RE: Valle Vista at the Trails, Unit 2 (File: C09D009)
Grading and Drainage Plan, Engineer's Stamp Date 6-23-2014
Revised Grading Plan, (verbally approved) Engineer's Stamp Date 1-20-15
Engineer's Certification Date: 3-18-16

Re: Grading and Drainage Certification, Valle Vista Unit 2
DRB Case No. 1004606, (C09/D009)

Enclosed is the final grading and drainage certification for Valle Vista Unit 2. Enclosed for your review is the approved grading and drainage plan dated 6/23/14, with as-built elevations. Your comments, dated December 7, 2015, have been addressed as noted below. Also attached per your request is a hard copy of the Unit 2 and 3 grading plan revision dated 1/20/15. It was agreed with Curtis that these revisions could be as-built on the approved grading plan. The as-built grading plan and my previous Unit 2 certification submittal, dated 10/22/15 incorporate and/or address the grading plan revisions.

VALLE VISTA UNITS 1, 2 & 3
GRADING AND DRAINAGE PLAN

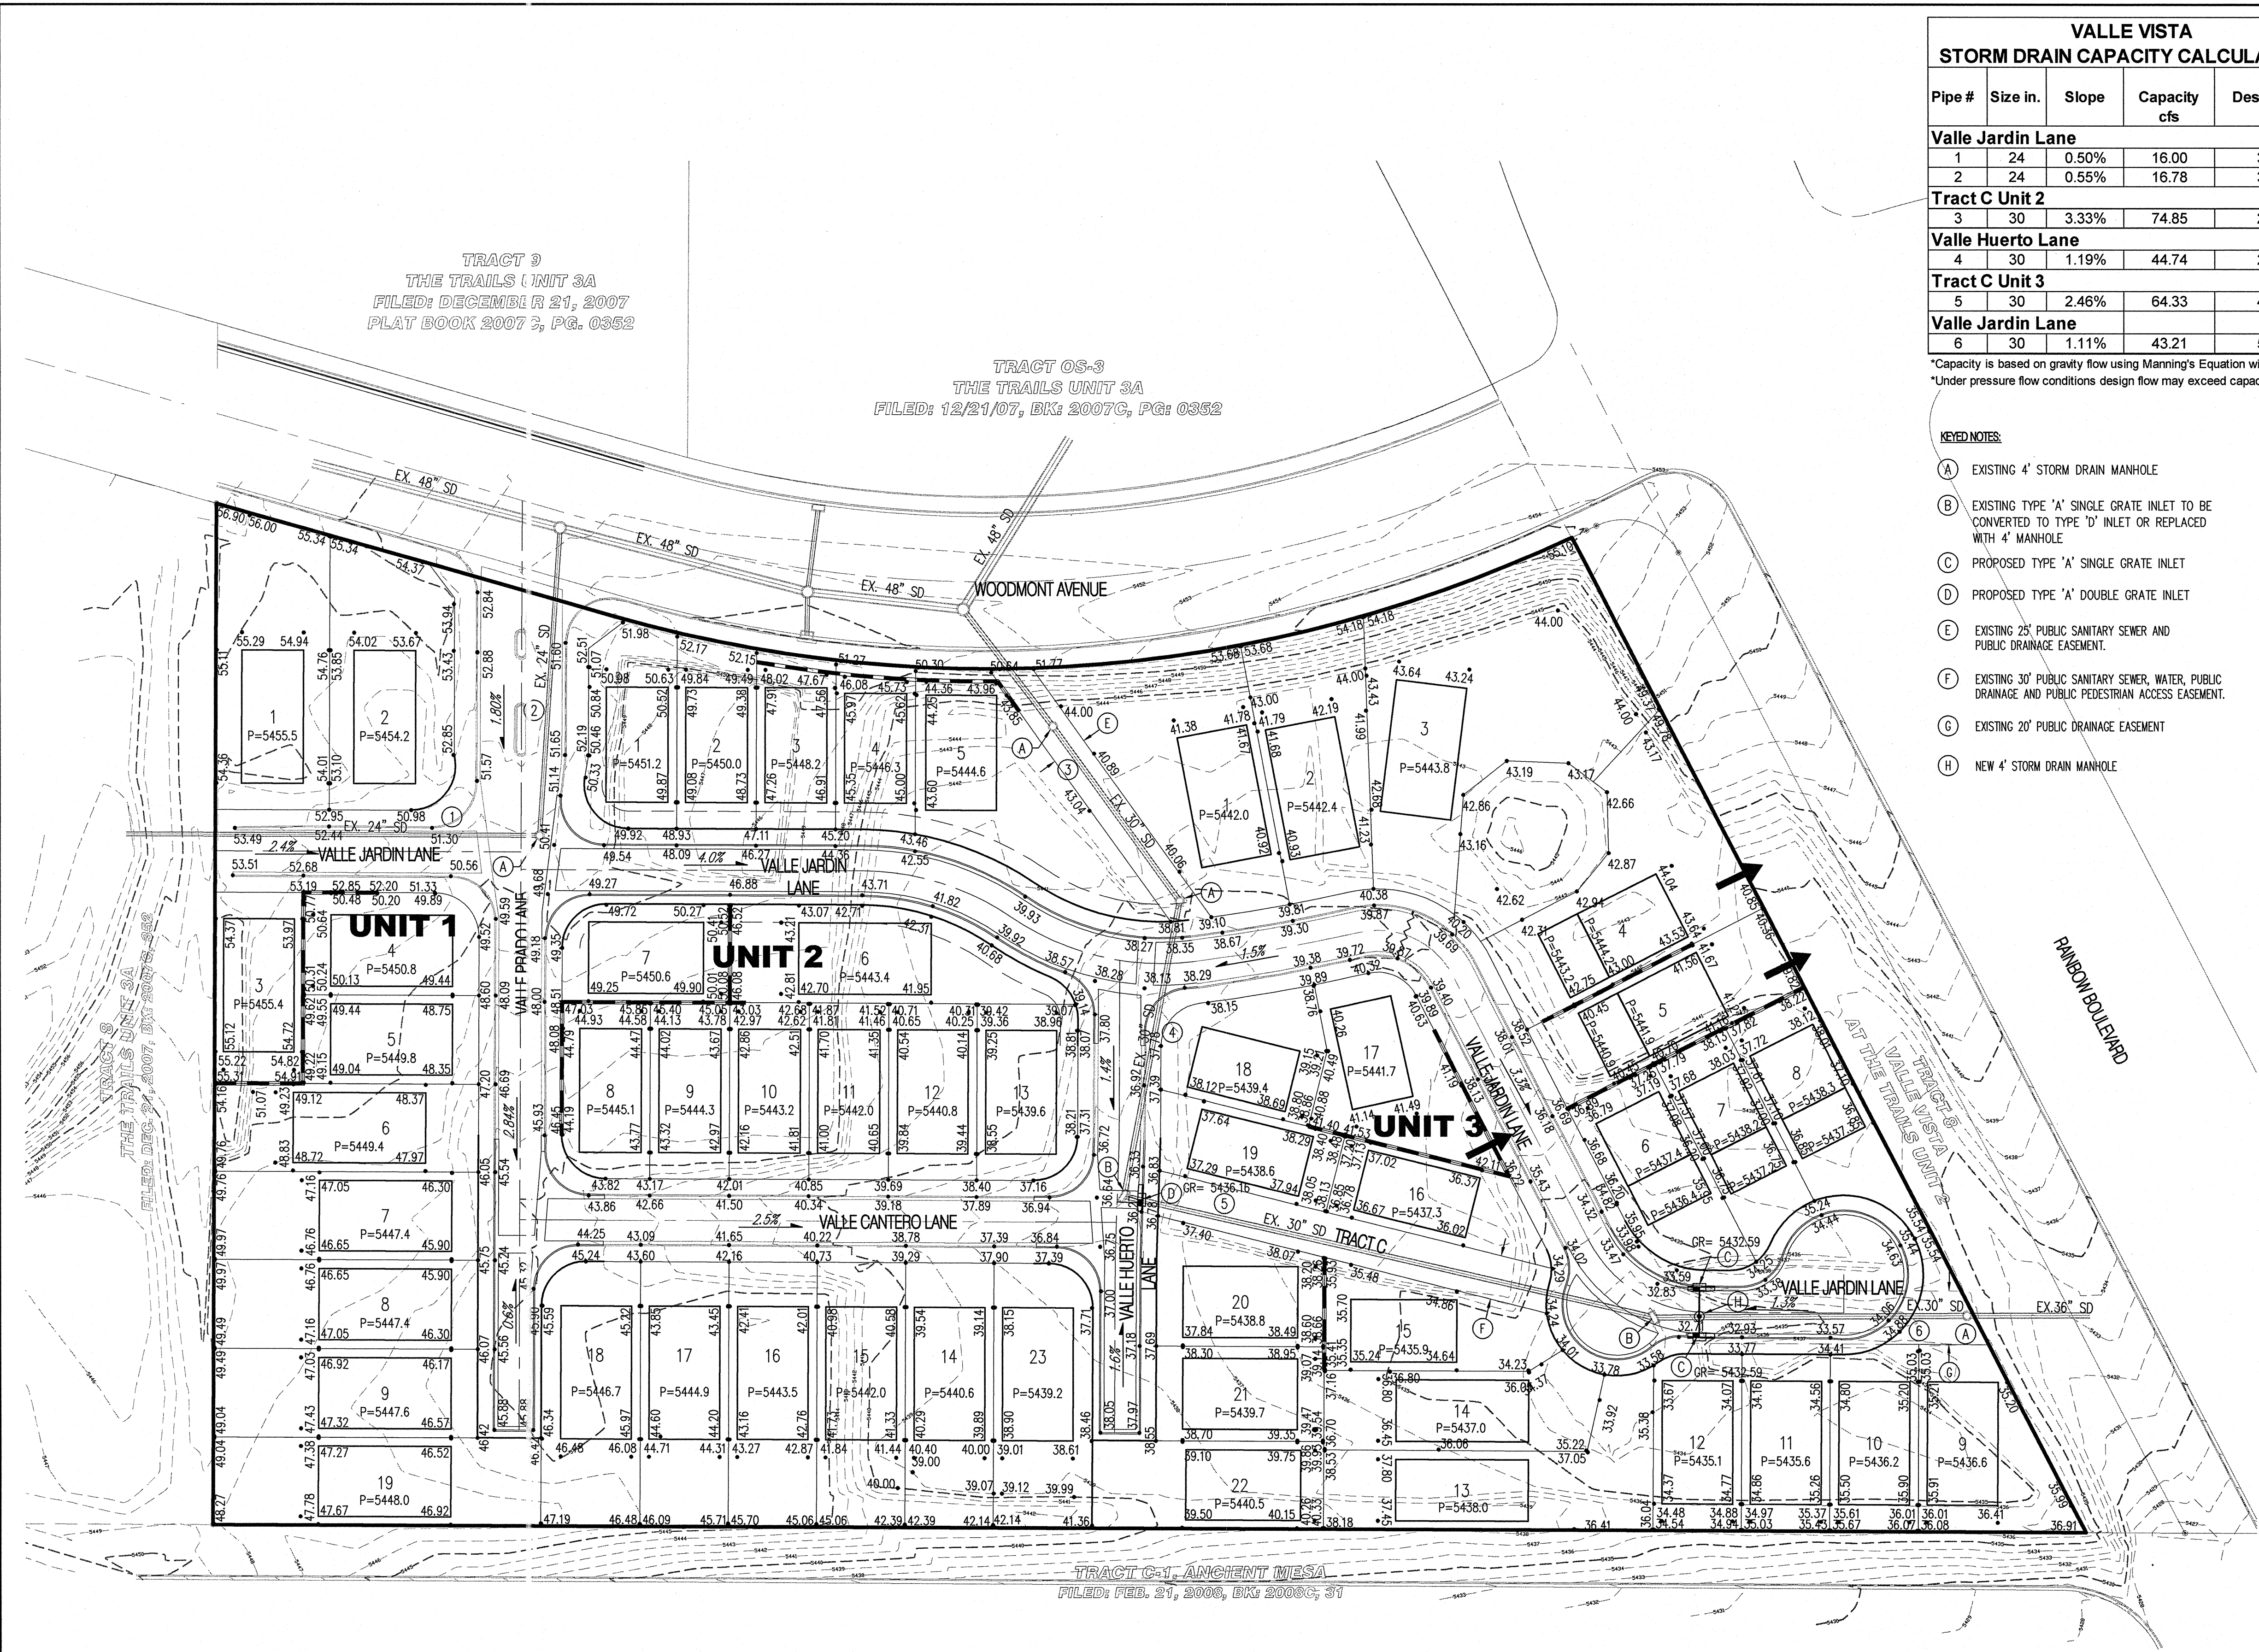
1. *This development discharges to Pond H, and as such the improvements to the Pond must be complete. The orifice plat is intended to allow for an opening of 1.14 SF and needs to resist over 3000 lbs of force without opening. Our field visit shows that the plates are already somewhat opened and need to be completely closed so that the opening does not exceed the 1.14 SF. The pin seems to be undersized. Show that the pin provided can maintain the plates remain completely closed under the 3000 lbs of force. Show that the pin will not shear with this amount of force. See attached picture. **It is my understanding that issues have been resolved and that at a subsequent field meeting with Rick Beltramo you stated that the Pond H improvements were acceptable.***

2. *The retaining wall at the rear of Lot 5 appears to have collapsed. **As previously discussed, the retaining wall has not collapsed, but actually turns an approximate 45 degree angle and steps down the slope.***

3. *Manhole is SD Tract east of Lot 5 needs to be adjusted to grade. **The manhole has been adjusted.***
4. *Lot 3 rear retaining wall is intended to be a garden wall retaining 2' to be built by the homebuilder. However, what mechanism is in place for the City to ensure that such a wall is built? If no such mechanism is in place, this wall should be constructed prior to Release of Financial Guarantee. Furthermore, should the garden wall not be built, the existing wall beyond is susceptible to overturning since the supporting soil is not in place. **The 2' garden wall has been built, see as-built elevations on the grading plan.***

5. *The split between Lots 7 and 8 is over 2', and needs a retaining wall per the plan. **See the revised grading plan dated 1/20/15. The split is 2' or less, which will be built as part of the garden wall by the homebuilder.***
6. *The split between Lots 6 and 7 is over 4', and needs a retaining wall per the plan. **See the revised grading plan dated 1/20/15. The property line split is 2', with a slope in the rear yard. The 2' split will be incorporated in the garden wall, which will be built by the homebuilder.***
7. *Valley gutter at intersection of Valle Prado Lane and Valle Cantero Lane is chipped along an edge, and the asphalt is not flush. **The valley gutter is part of the Unit 1 infrastructure which has been accepted by the City. In addition, the streets in Valle Vista are private.***
